Development Application No.: SSD-10-444  
Description of Development: Blue Gum Community School  
Property: Lot A DP 327582  
1 Rosemead Road, Hornsby

Thank you for the opportunity to comment on the Environmental Impact Statement for the proposed Blue Gum Community School State Significant Development (SSD-10-444). Council officers have reviewed the submitted documentation available on the Major Projects web portal and the following comments are provided for consideration by the Department.

### ***Heritage Assessment***

MOUNT ERRINGTON GATES AT ROSEMEAD ENTRANCE TO BE RELOCATED TO VEGETABLE GARDEN IN OUTDOOR PLAY AREA

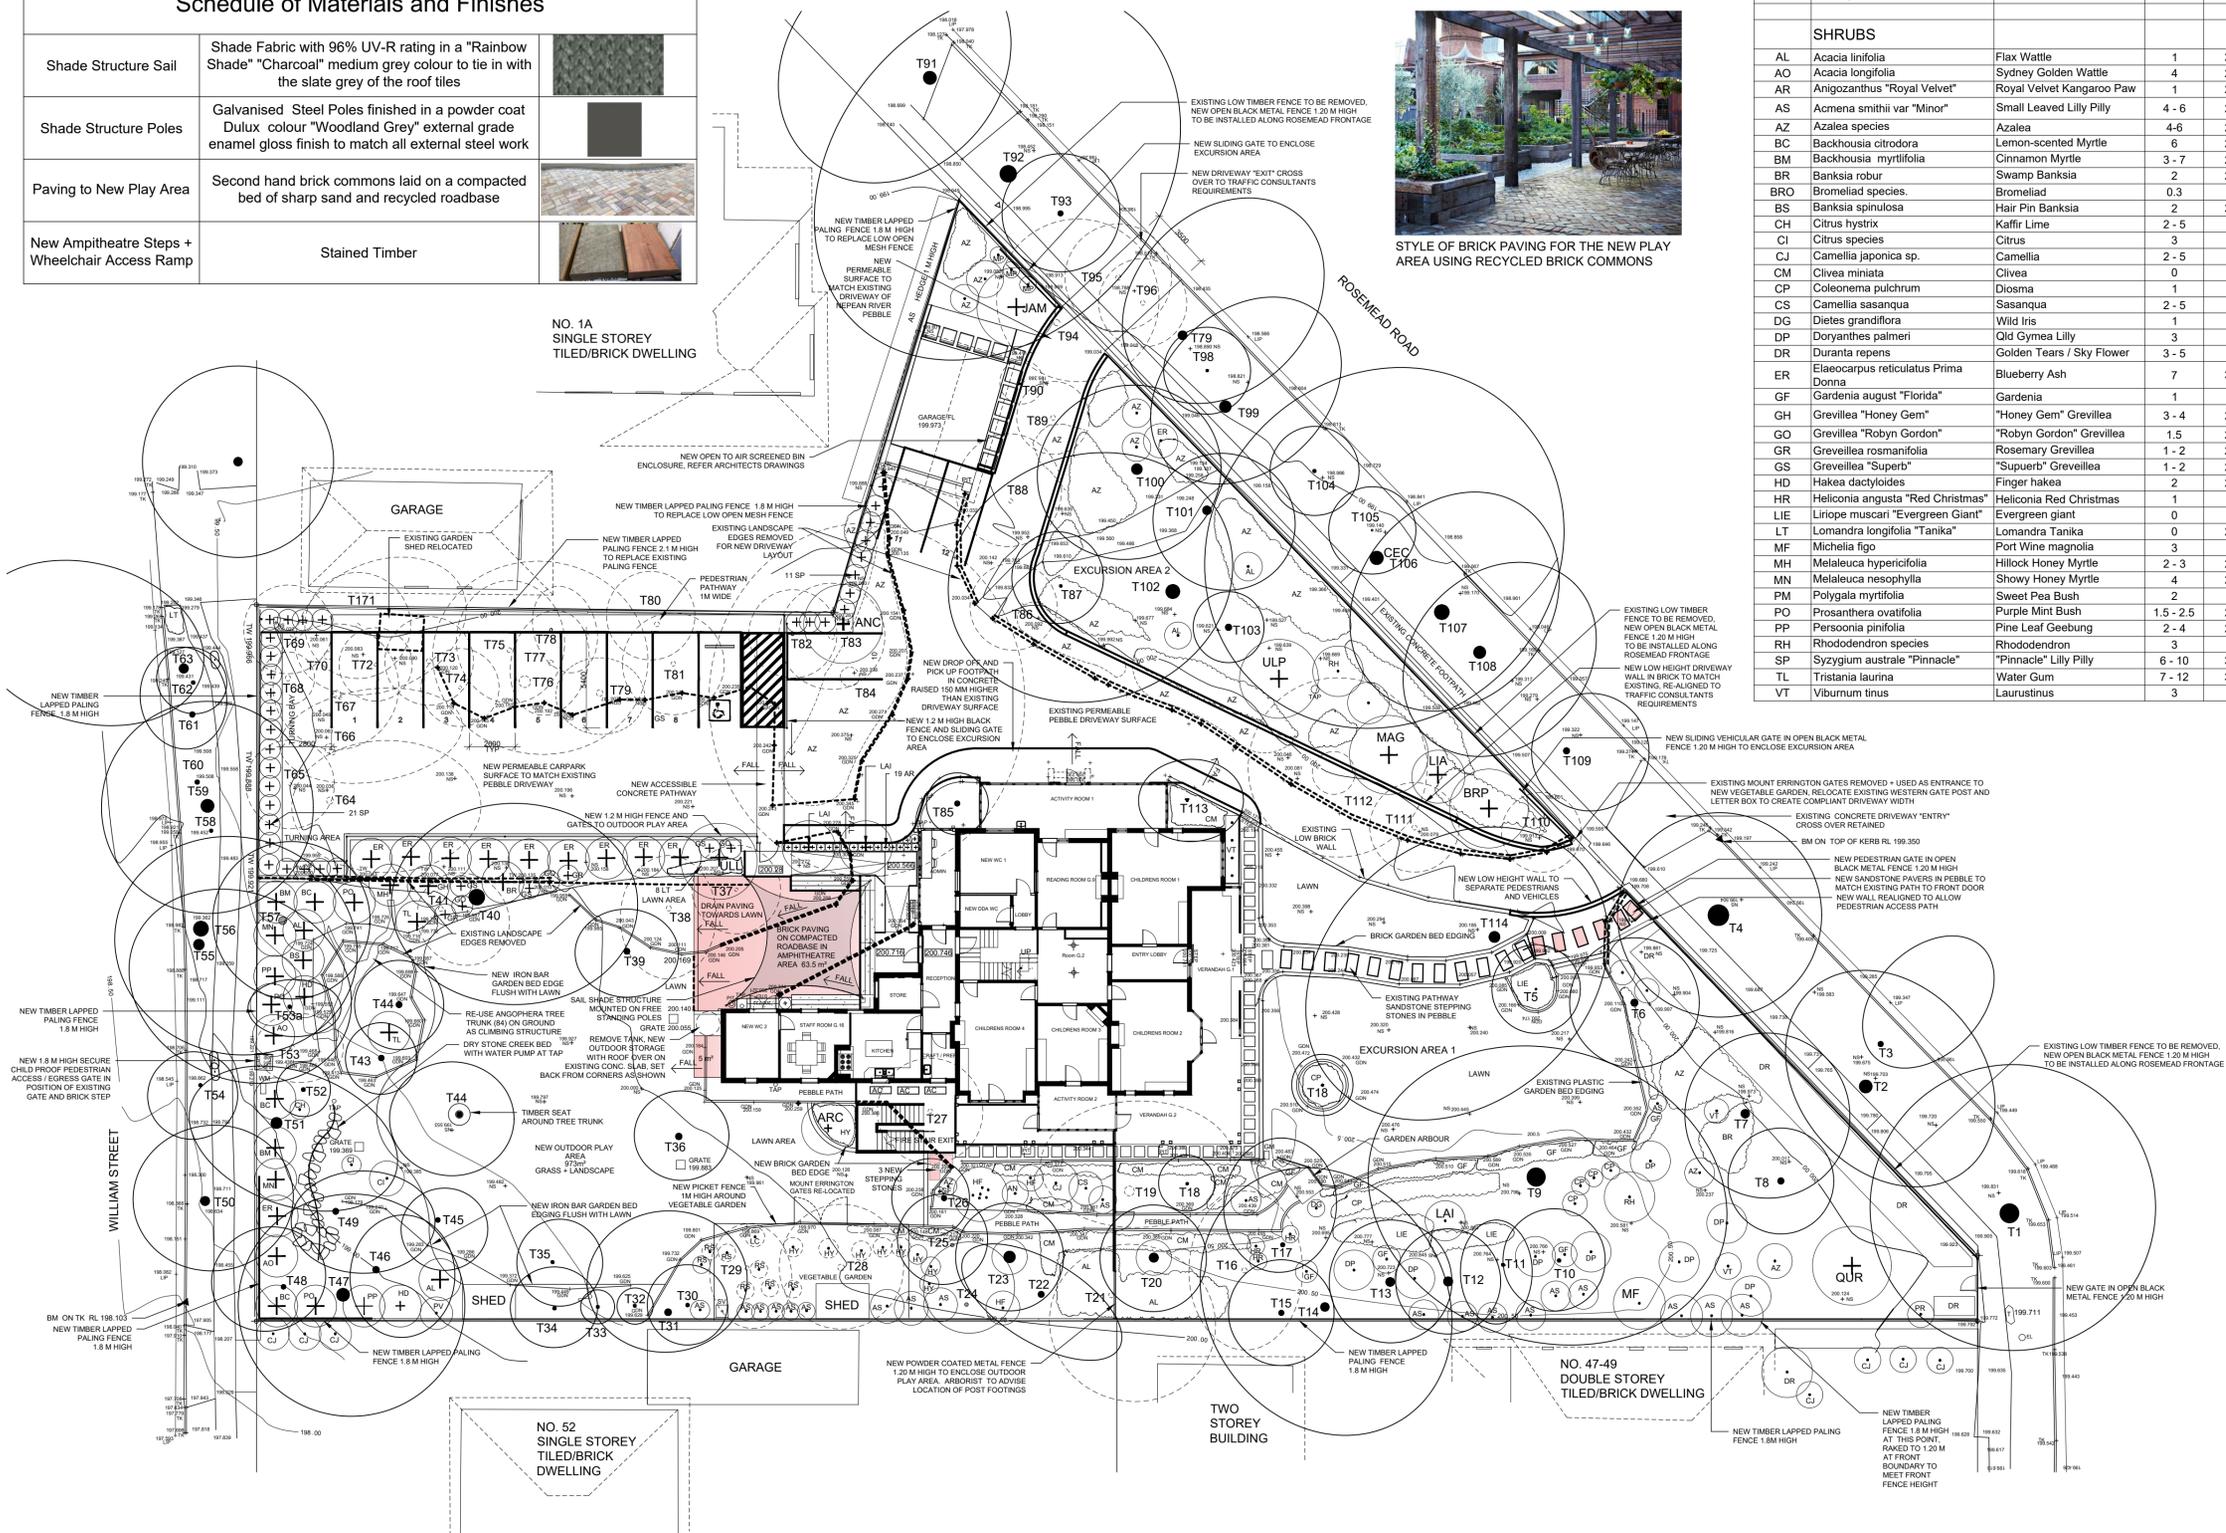
| <b>Proposed Works</b>  | <b>Impact</b>  | <b>Comment</b>   |
|--|--|--|
| 4. Existing Mount Errington gates and posts                                      | Adverse Impact<br>Amendments required (see recommendation d) | <p>The existing gates and posts are original, highly significant and a landmark feature of the site and HCA with views to, and from, the public domain. Removal, relocation and repurposing of elements would have a detrimental impact on the integrity of the site, the interpretation of the property and its landmark status within the HCA.</p> <p>The existing entry gates and posts should remain insitu. An alternative design solution should be investigated to meet heritage requirements.</p> <p><b>The proposal does not comply with Section 9.2.4 Desired Outcomes (a); Prescriptive Measures (a) and (b).</b></p> |

| <b><i>Proposed Works</i></b>  | <b><i>Impact</i></b>  | <b><i>Comment</i></b>  |
|---|---|--|
|   |   | <p>replacement with metal black fencing does not complement the heritage significance of the property, the architectural style of the dwelling or the streetscape character of the HCA. It would be obtrusive and unsympathetic to the heritage values of the site and HCA.</p> <p>Any new fencing design and materials should be based on historic evidence, historically accurate to the period and style of the dwelling, and reflect the materials used within the site. An alternative solution should be investigated to meet heritage and regulatory requirements.</p> <p><b><i>The proposal does not comply with Section 9.2.4 Desired Outcome (b); Prescriptive Measures (c), and (d); Section 9.3.3 Desired Outcomes (a) and (c); Prescriptive Measures (j), and (k).</i></b></p>  |

| d) Existing Mount Errington gates and posts                | <ul style="list-style-type: none"> <li>• <b><i>The proposal does not comply with Section 9.2.4 Desired Outcomes (a); Prescriptive Measures (a) and (b).</i></b></li> <li>• The original gates and posts should be retained in-situ;</li> <li>• Alternative solution to meet heritage requirements.</li> </ul>  |
| e) Existing timber fence replacement                       | <ul style="list-style-type: none"> <li>• <b><i>The proposal does not comply with Section 9.2.4 Desired Outcome (b); Prescriptive Measures (c), and (d); Section 9.3.3 Desired Outcomes (a) and (c); Prescriptive Measures (j), and (k).</i></b></li> <li>• Alternative design, materials and finish to meet heritage and regulatory requirements.</li> </ul>   |
